28 November 2014

BORG PANELS – PROPOSED COGENERATION PLANTS

I refer to your letter to the Environment Protection Authority (EPA) dated 24 November 2014 in relation to Borg Panels Pty Limited's (Borg Panels) intention of commissioning two cogeneration units at your Oberon facility.

Figure 3: Site layout and location of the proposed cogeneration units

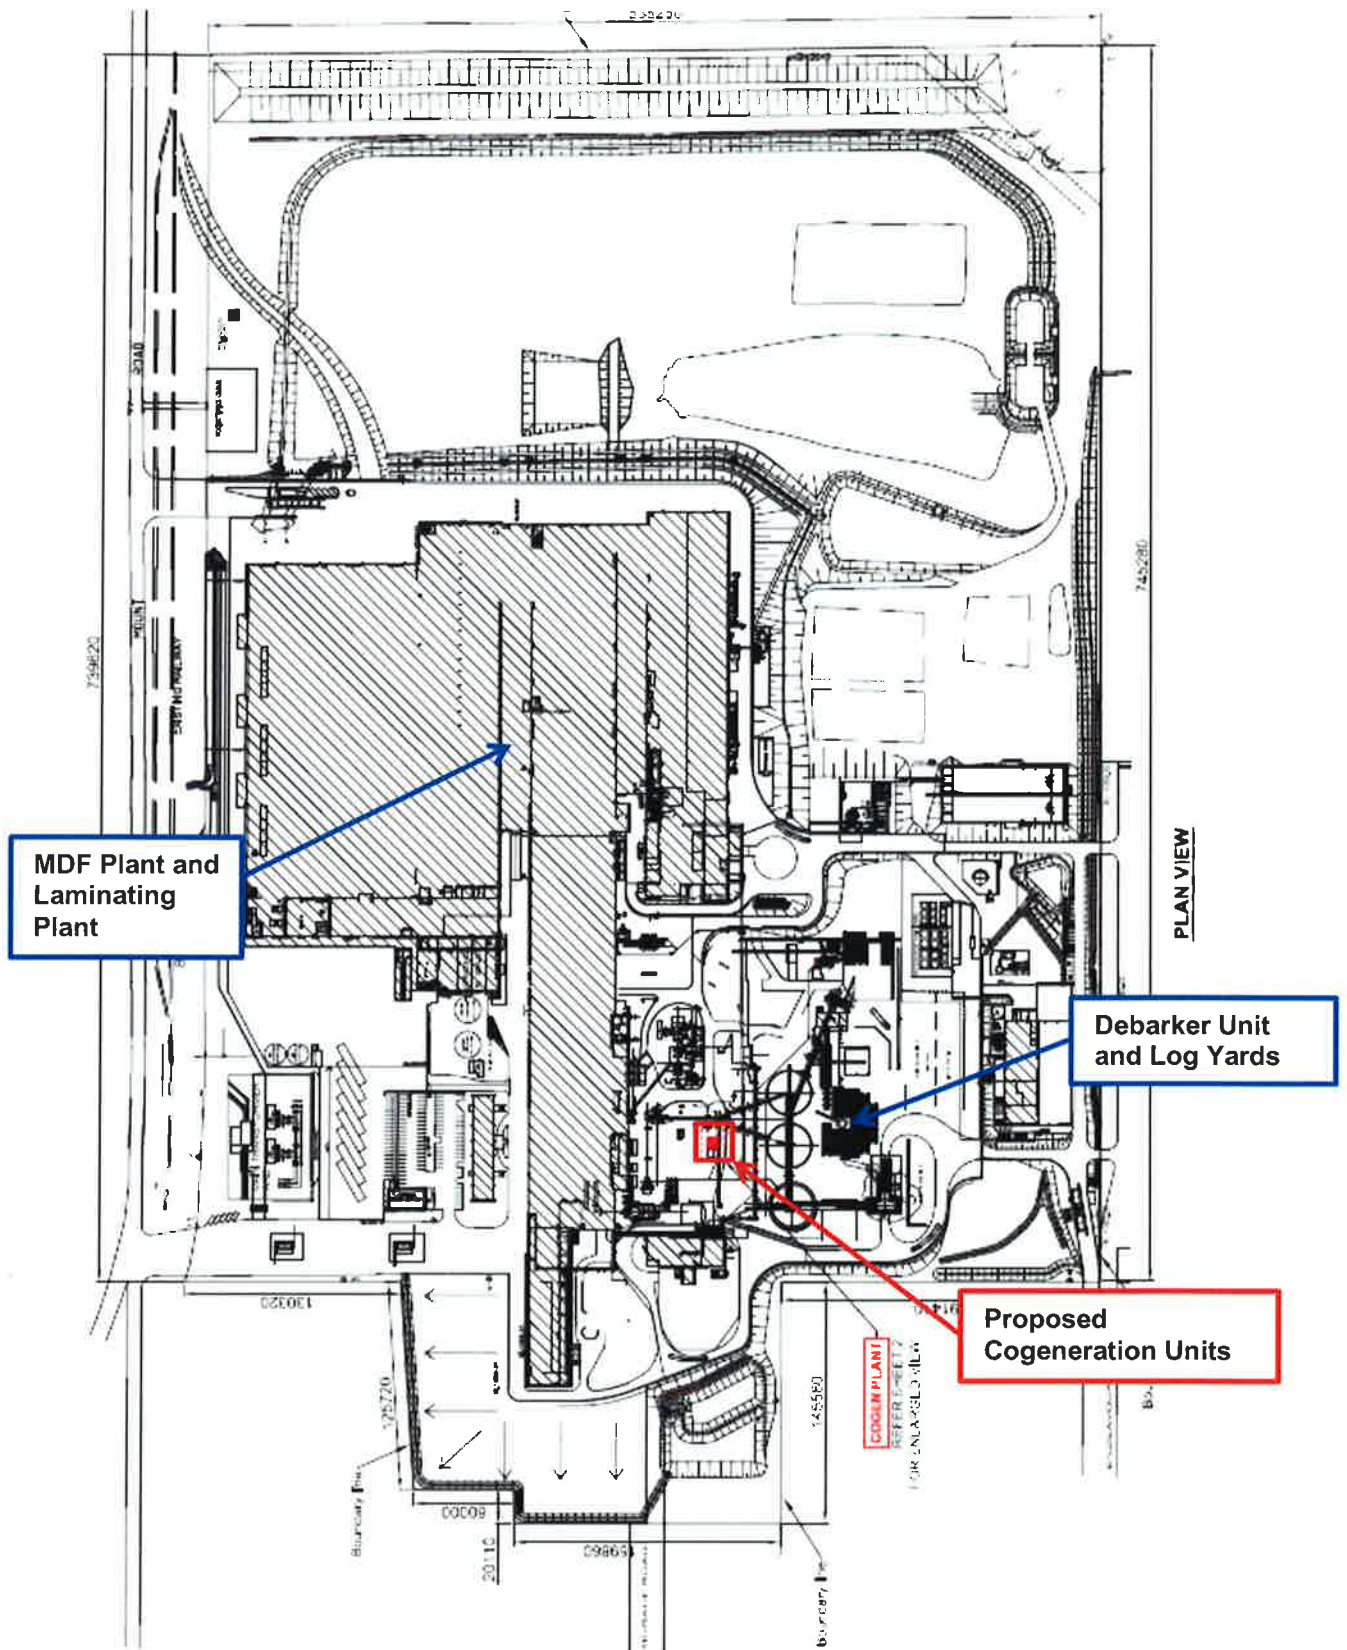
Your letter states that the cogeneration units will be housed within 'noise reducing enclosures' completely sealed from the outside environment and lined with 'appropriate noise absorbing materials'. Your letter also states that the current environment protection licence 'provides for the noise requirements' associated with the operation of the units.

The plant specifications for the Duetz TBG 620 V12 K states an exhaust noise of 120 dB(A) and an air-borne noise of 102 dB(A). The licence night time noise limit is 45 dB(A). While you may state the plant will be housed within a completely sealed noise reducing enclosures that will be lined with "appropriate" noise absorbing material, you need to provide information that demonstrates that the noise reducing enclosures will achieve sufficient noise attenuation such that the operation of the two cogeneration units will not lead to an increase in the local noise environment and the potential to exceed the premises' noise criteria – particularly the night time limit of 45 dB(A). The EPA would require that noise monitoring be undertaken following the commissioning of these units to ensure that the required level of attenuation has been achieved.
